16th July 2012

Application for Planning Permission for Works or Extension to a Dwelling

Development Add a pitched roof to the existing flat roofed garage (including new gables), raise the door/eaves level & install a single full garage door to the front elevation

Location 34 Halliford Drive Barnham Bognor Regis

0214-12-02

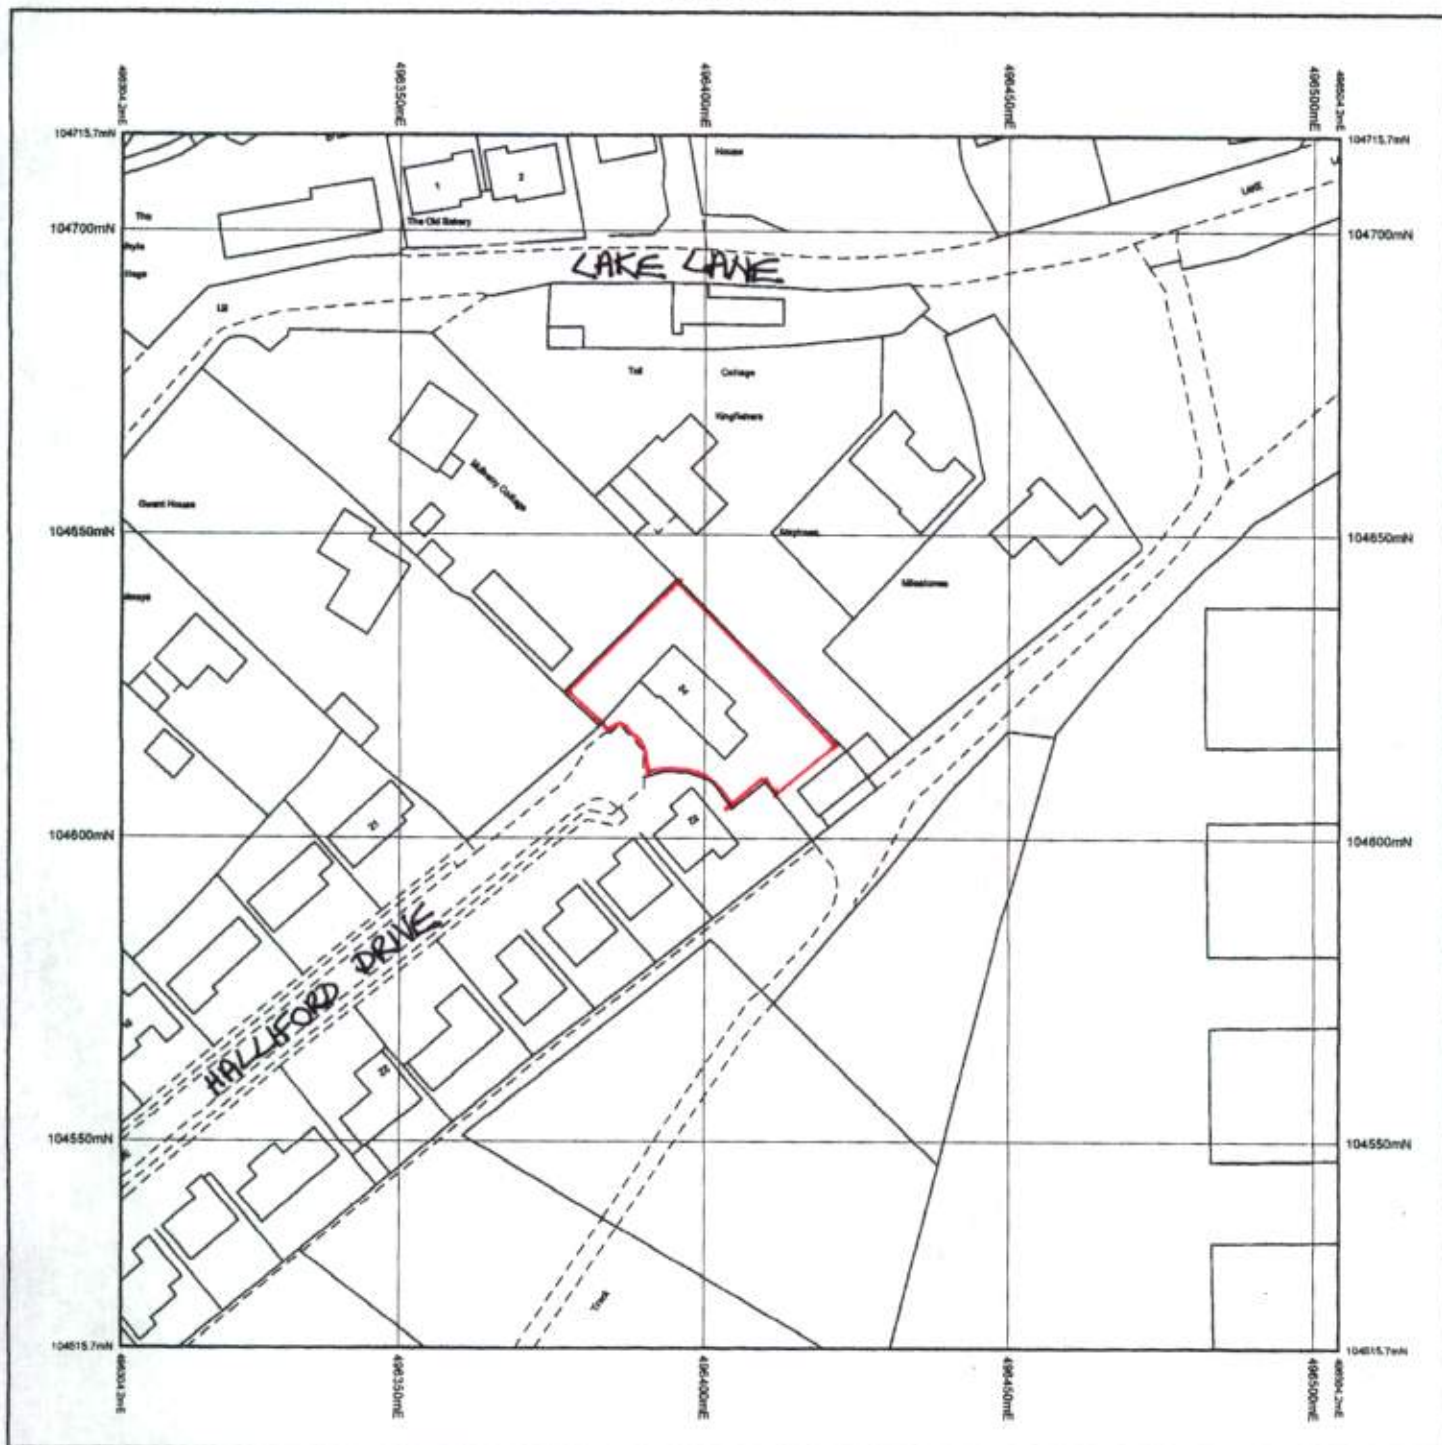
I require 1 electronic or 3 paper copies of a revised location plan showing 2 named roads, in accordance with the guidance notes available on our website detailed below (click on National List).

SIDE (N-E) ELEVATION

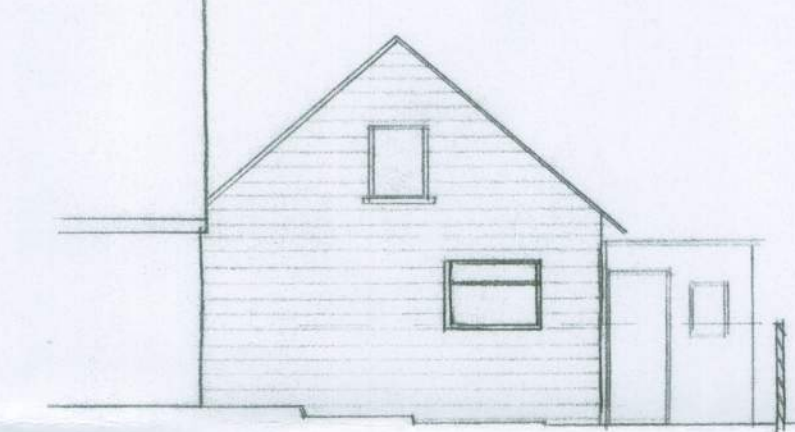
Please provide 1 electronic or 3 paper copies of a revised proposed floor plan to show the 2 windows shown on the proposed side north east elevation.

ROOF PLAN-EXISTING 1:100

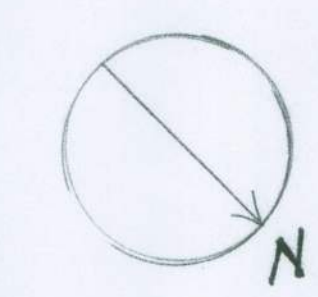
Please submit 1 electronic or 3 paper copies of an existing roof plan.
